Application Ref:	3/2021/0462	 <b>Ribble Valley Borough Council</b> <a href="http://www.ribblevalley.gov.uk">www.ribblevalley.gov.uk</a>
Date Inspected:	13/5/2021	
Officer:	AD	
DELEGATED ITEM FILE REPORT:		Decision      Refusal

Development Description:	Retention of rear boundary fence, garden shed and garden room/office.
Site Address/Location:	1 Park Road Gisburn BB7 4HT

## Appendix C – Zones of Visibility

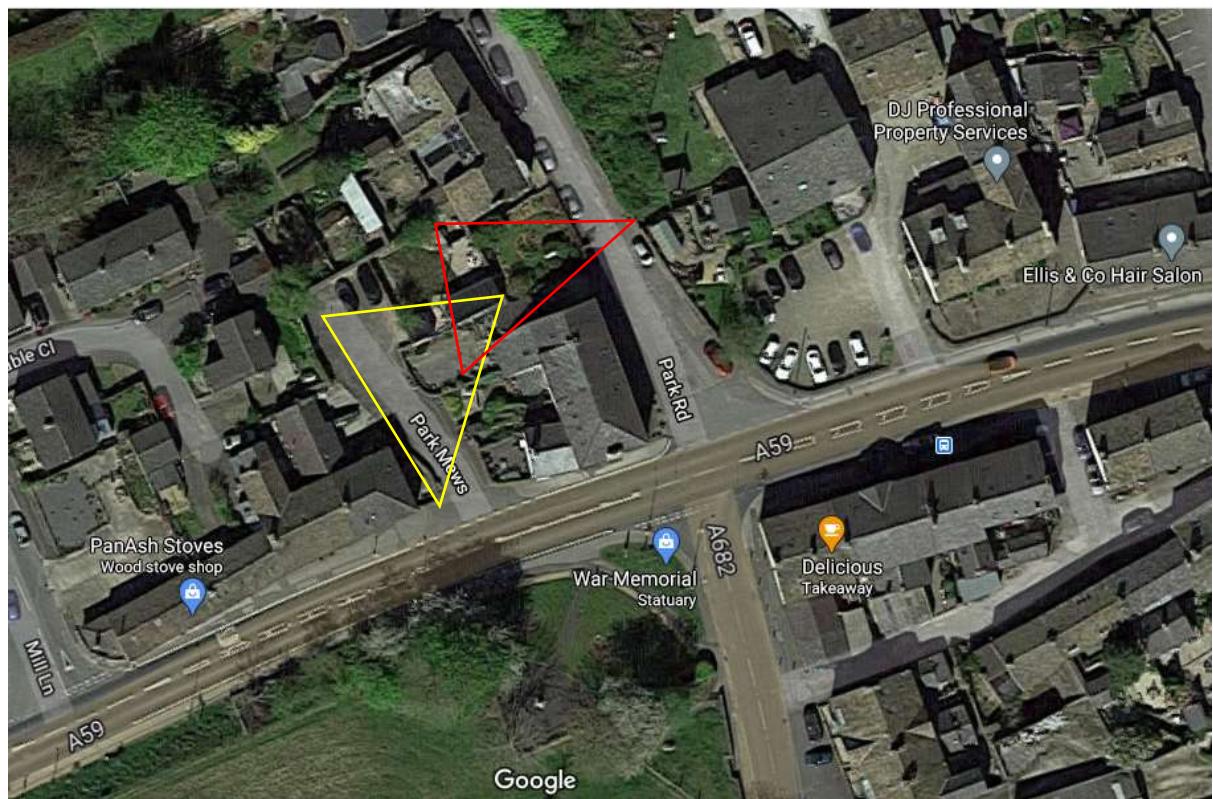
The submitted Heritage Impact Assessment suggests that a hedgerow screen planted immediately behind the front wall and railings fronting onto Park Road (height of 2m in 5 years) is sufficient mitigation for this harm ('harm' is identified by the applicant within the first paragraph of the Heritage Impact Assessment: Conclusions). However, the open and raised garden is an important, befitting and fortuitous element of 1 Park Road's setting and Park Road townscape which screening will harm. This part of the garden may not be historically associated with 1 Park Road. However, the NPPF Glossary: Setting of a heritage asset definition is “*the surroundings in which a heritage asset is experienced. Its extent is not fixed and may change as the asset and its surroundings evolve*”. ‘The Setting of Heritage Assets’ (Historic England, 2017) identifies “*As screening can only mitigate negative impacts, rather than removing impacts or providing enhancement, it ought never to be regarded as a substitute for well-designed developments within the setting of heritage assets. Screening may have as intrusive an effect on the setting as the development it seeks to mitigate*” (paragraph 40). Furthermore, note is made of the recent appeal at 2 Moorend Cottages, Langho (APP/T2350/W/20/3251911; 25/8/2020) in which the Planning Inspector concluded “*in any case, while planting can help assimilate development into its surroundings, it should not be used to screen inappropriate development from view*”.

LAYOUT PLAN

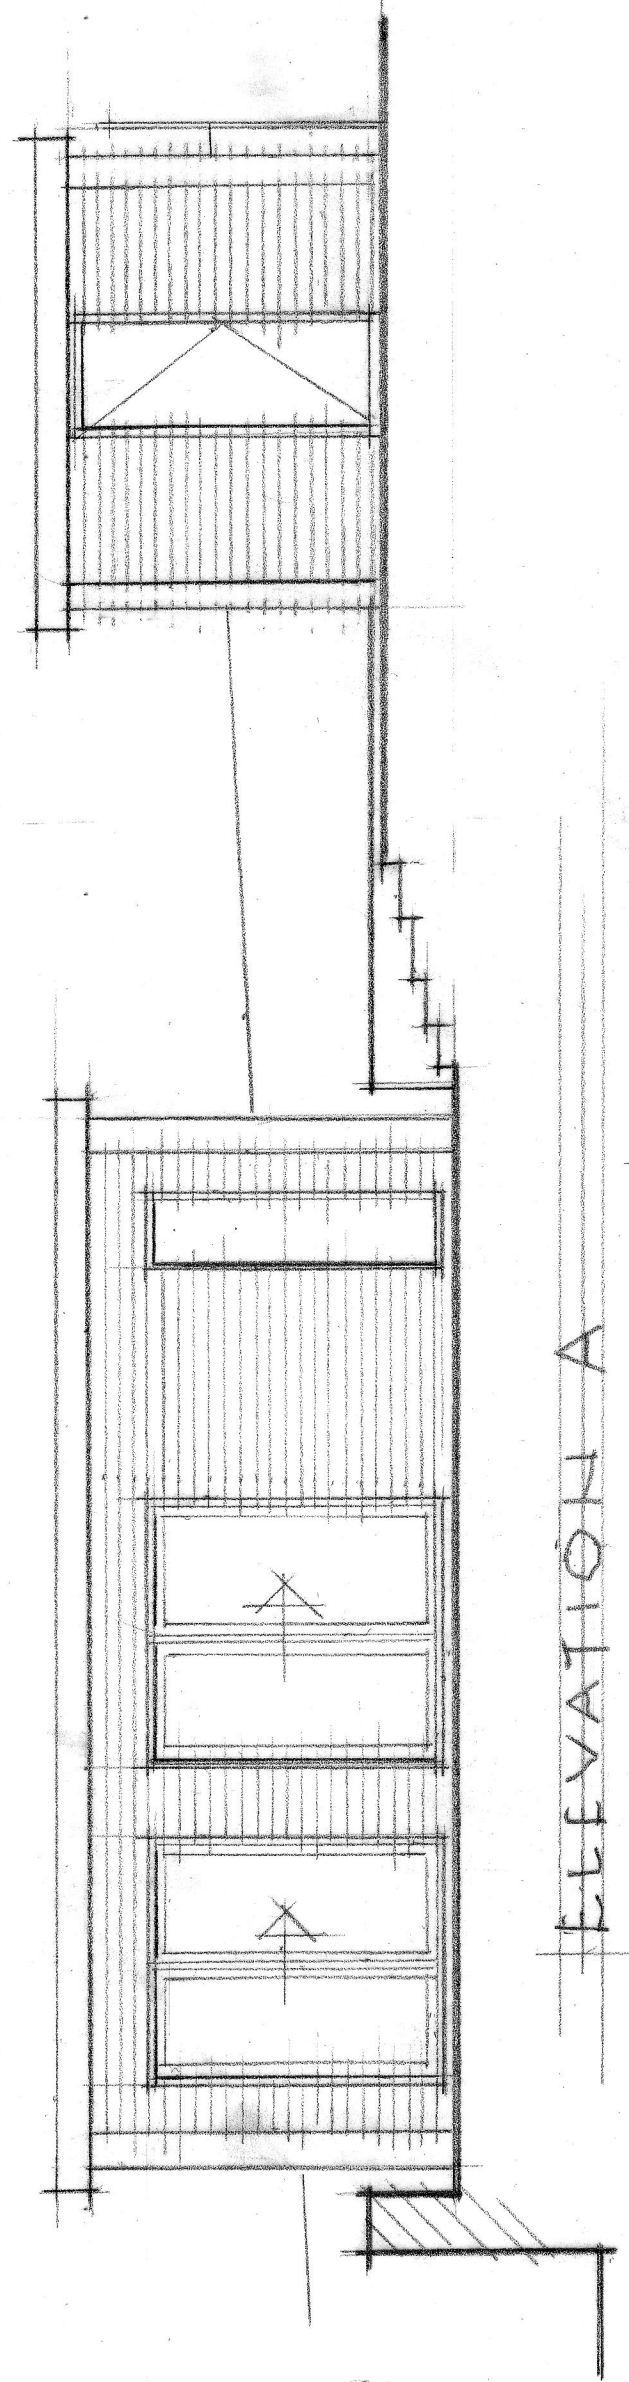
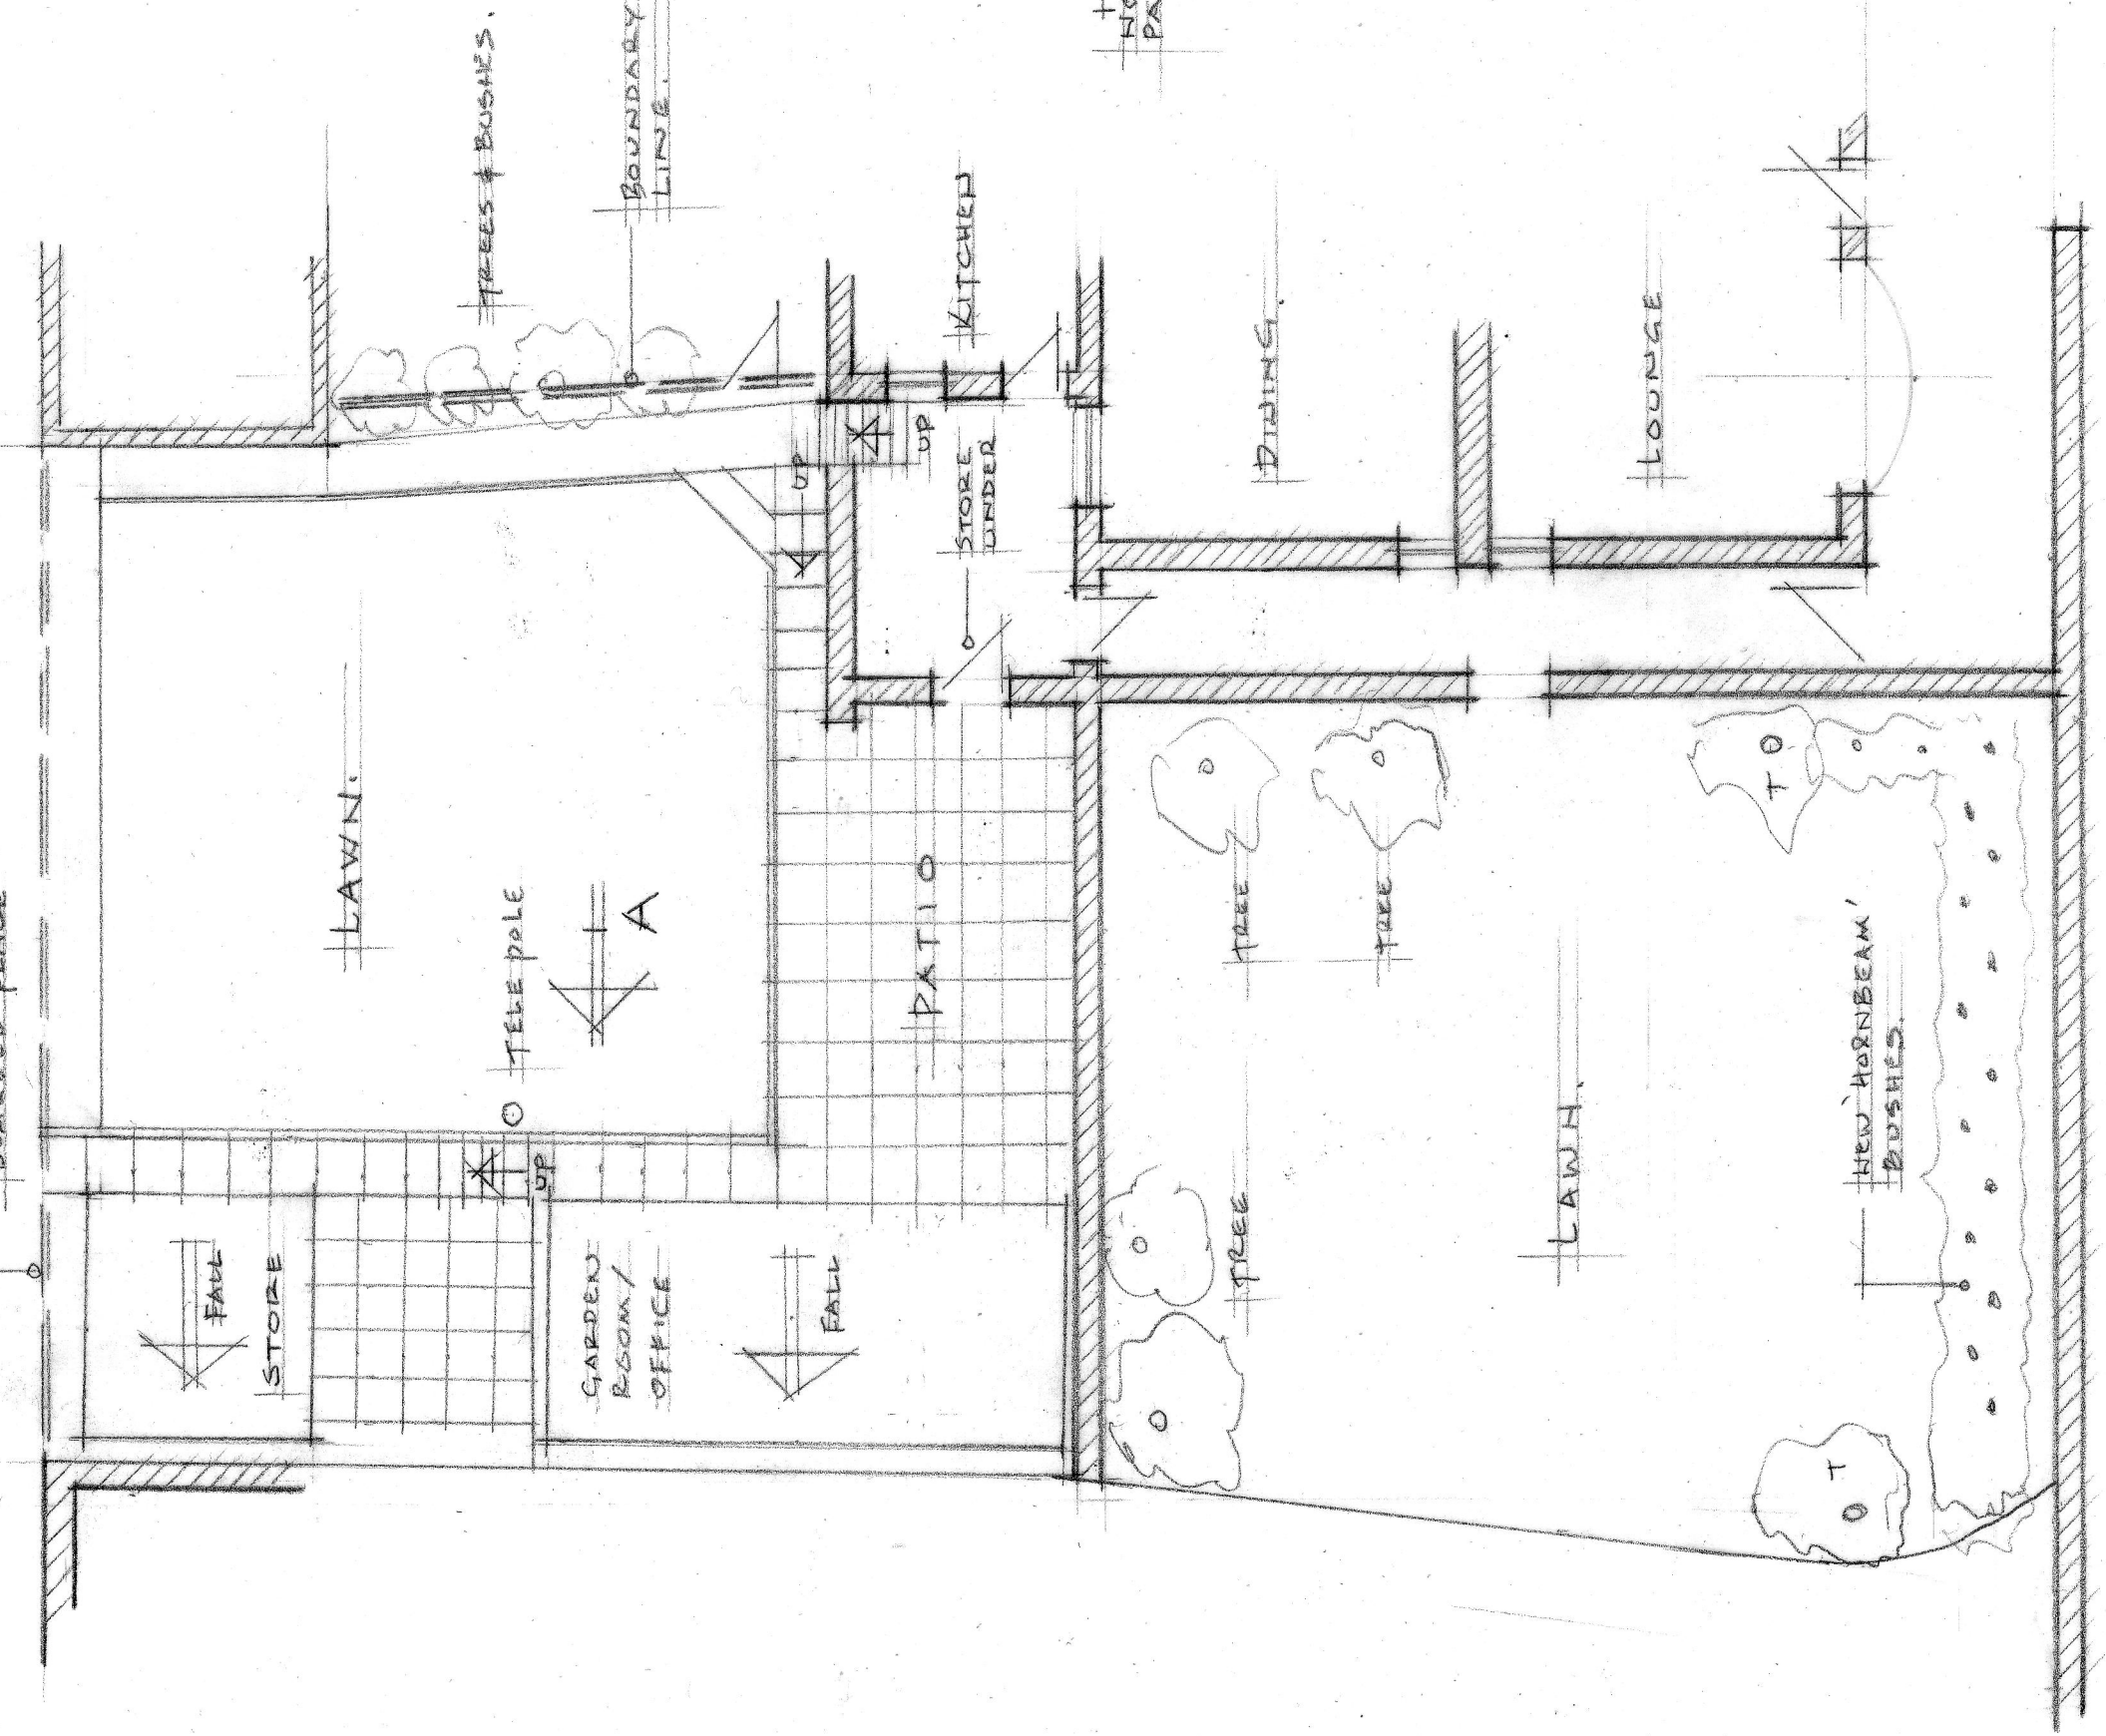
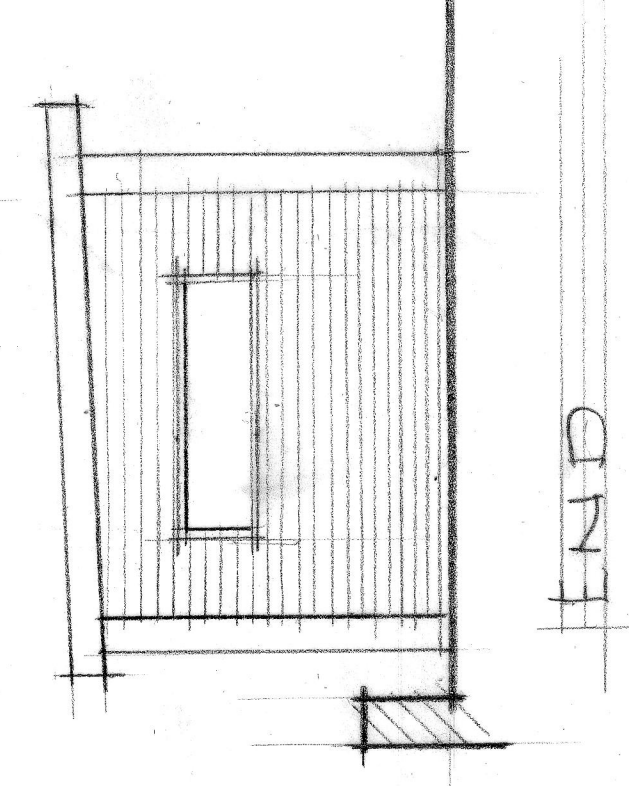
Planning permission is sought for the retention of a fence (west boundary) and two low mono-pitched outbuildings (shed and garden room/office adjoining the south boundary) in the raised garden area to the south of 1 Park Road. The fence and building walls are timber; roofs and window/glazed door frames in aluminium (although materials not identified in the submitted information).

The development is unduly prominent, incongruous and conspicuous because of its siting in the raised garden, low mono-pitched roof form and timber and aluminium materials and has a harmful impact upon the setting of listed buildings (particularly 1 Park Road) and the character and appearance of Gisburn Conservation Area.

The development is also incongruous and conspicuous and predominates in views of the historic Park Road building row from the south because of its siting, form and materials.

That planning permission be refused for the following reason:  
The development has a harmful impact upon the setting of listed buildings and the character and appearance of Gisburn Conservation Area because it is unduly prominent, incongruous and conspicuous as a result of siting, roof form and materials. This is contrary to Key Statement EN5 and Policies DME4 and DMG1 of the Ribble Valley Core Strategy.
